March 30, 2020

Re: Zitro Event Center
12910 Central Ave. SE
Traffic Circulation Layout
Architect's Stamp 03-05-20 (L22-D059A)

Based upon the information provided in your submittal received 03-30-20, the above referenced plan cannot be approved for Building Permit until the following comments are addressed:

SHEET NAME:
TRAFFIC CIRCULATION LAYOUT

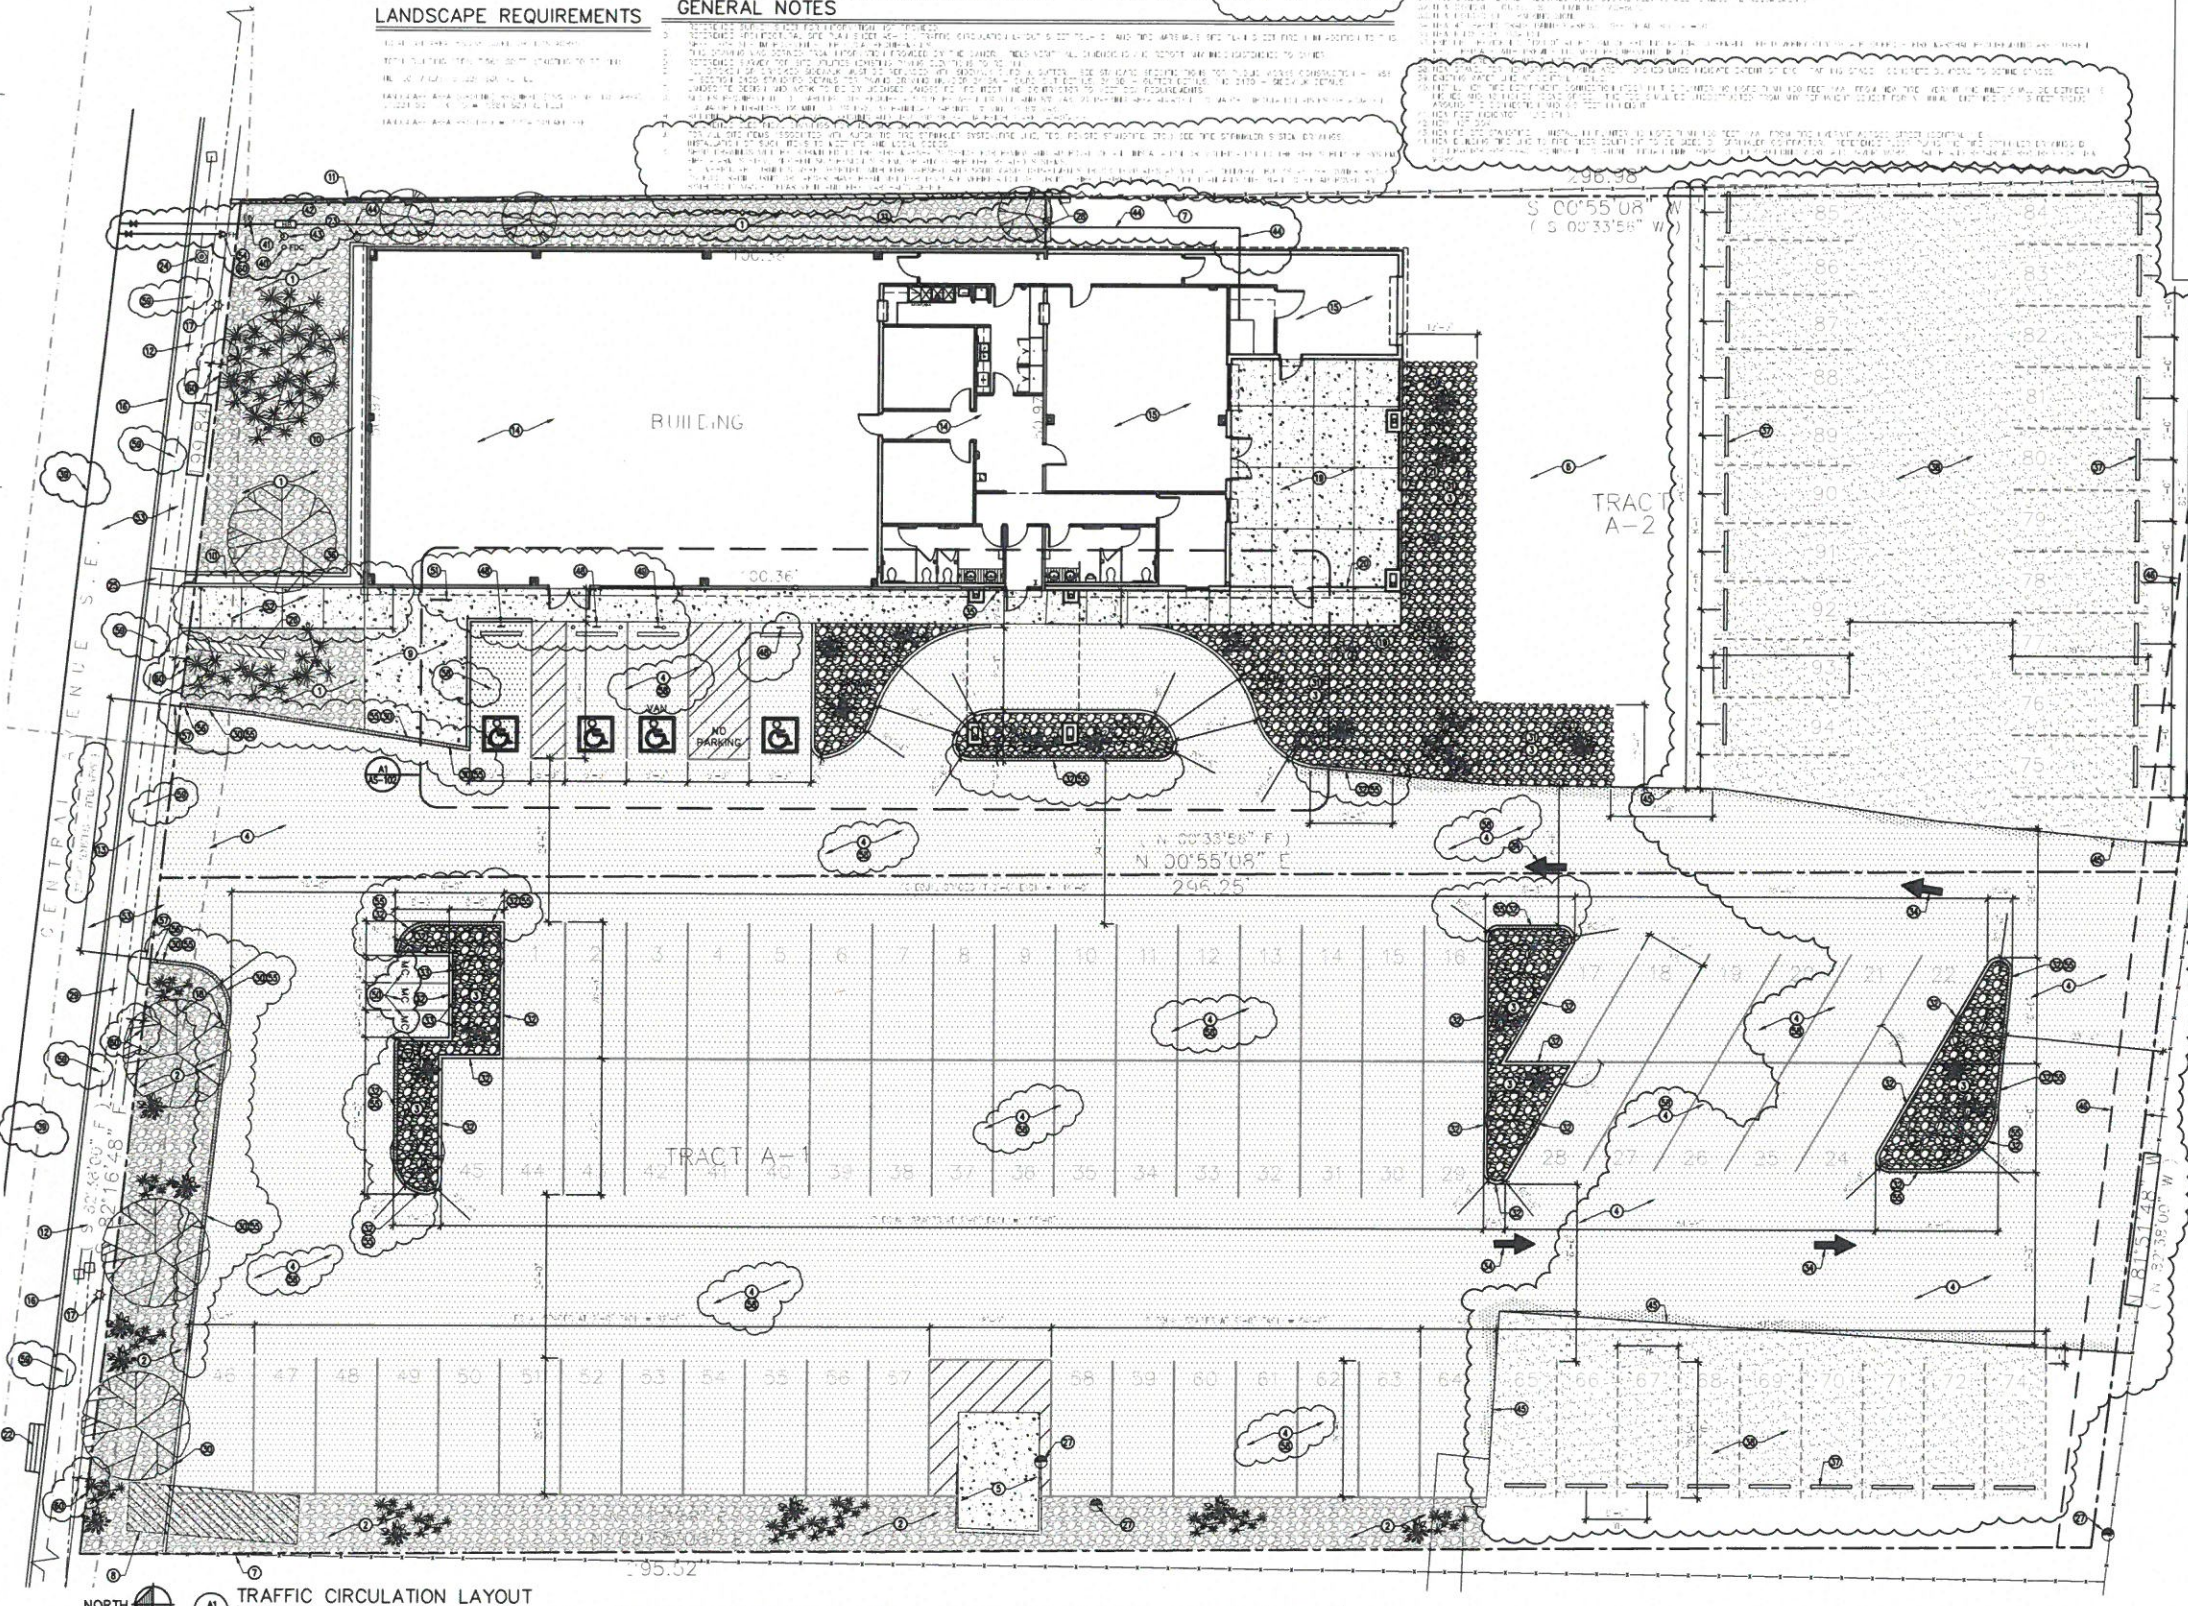
1. Please coordinate all calculations for parking spaces, including bicycle, and motorcycle parking with Zoning and list the number of parking spaces required by the zoning code as well as the proposed number of parking spaces including bicycle and motorcycle parking.
2. Please identify all existing structures, drive pads (provide detail of existing), wall, land anything that influences the parking and circulation, and site distance on the site.
3. Identify all existing access easements and rights of way width dimensions.
4. Please list the widths and lengths for all existing and parking spaces. Some dimensions are not shown.
5. The minimum parking stall dimensions are:

6. The ADA accessible spaces must include an access aisle. Van accessible aisles should be 8ft wide; all others should be 5ft wide. Provide on plans.
7. The ADA accessible parking sign must have the required language per 66-7-352.4C NMSA 1978 **"Violators Are Subject to a Fine and/or Towing."** Please call out detail and location of signs.

8. Motorcycle parking spaces shall be designated by its own conspicuously posted upright sign, either free-standing or wall mounted per the zoning code. Label pavement MC.

9. All bicycle racks shall be designed according to the following guidelines:
 - a. The rack shall be a minimum 30 inches tall and 18 inches wide.
 - b. The bicycle frame shall be supported horizontally at two or more places. Comb/toaster racks are not allowed.

10. Bicycle racks shall be sturdy and anchored to a concrete pad.
11. A 1-foot clear zone around the bicycle parking stall shall be provided.
12. Bicycle parking spaces shall be at least 6 feet long and 2 feet wide.

13. Show all drive aisle widths and radii. Some dimensions are not shown.
14. The minimum drive aisle (existing/proposed) dimensions are shown below

15. List radii for all curves shown; for passenger vehicles. Radius for delivery trucks, fire trucks, etc. is 25 ft. or larger.
16. Per the IDO, a **clear** 6 ft. wide ADA accessible pedestrian pathway is required from the public sidewalk to the building entrances. Please clearly show this pathway and provide details.
17. Per DPM, a **clear** 6 ft. wide ADA accessible pedestrian pathway is required from the ADA parking stall access aisles to the building entrances. Please clearly show this pathway and provide details.
18. Provide a copy of refuse approval with the new proposed parking configuration.
19. It is not apparent what type of pavement surface is being proposed. A hard driving surface will be required as part of this proposed project for ADA parking area.

20. Please provide a sight distance exhibit..
21. Show the clear sight triangle and add the following note to the plan:
"Landscaping and signage will not interfere with clear sight requirements.
Therefore, signs, walls, trees, and shrubbery between 3 and 8 feet tall (as measured from the gutter pan) will not be acceptable in the clear sight triangle.

22. Please specify the City Standard Drawing Number when applicable.
23. Shared Site acces: driveways that straddle property lines, or are entirely on one propertybut are to be used by another property, shall have an access easement. Please include a copy of your shared access agreement with the adjacent property owner.

26. Please add a note on the plan stating "All improvements located in the Right of Way must be included on the work order."
27. Unused curb cuts must be replaced with sidewalk and curb & gutter. A build note must be provided referring to the appropriate City Standard drawing (**if applicable**).

28. Add a note stating "All broken or cracked sidewalk must be replaced with sidewalk and curb & gutter" (fronting Central Ave.). A build note must be provided referring to the appropriate City Standard drawing.

29. Any private structures and/or landscaping (proposed or existing) that are located within public right-of-way such as fences walls, and landscaping shall either be removed or else a revocable permit with the City is required in which an annual fee is paid per year, based on square footage of the encroachment.
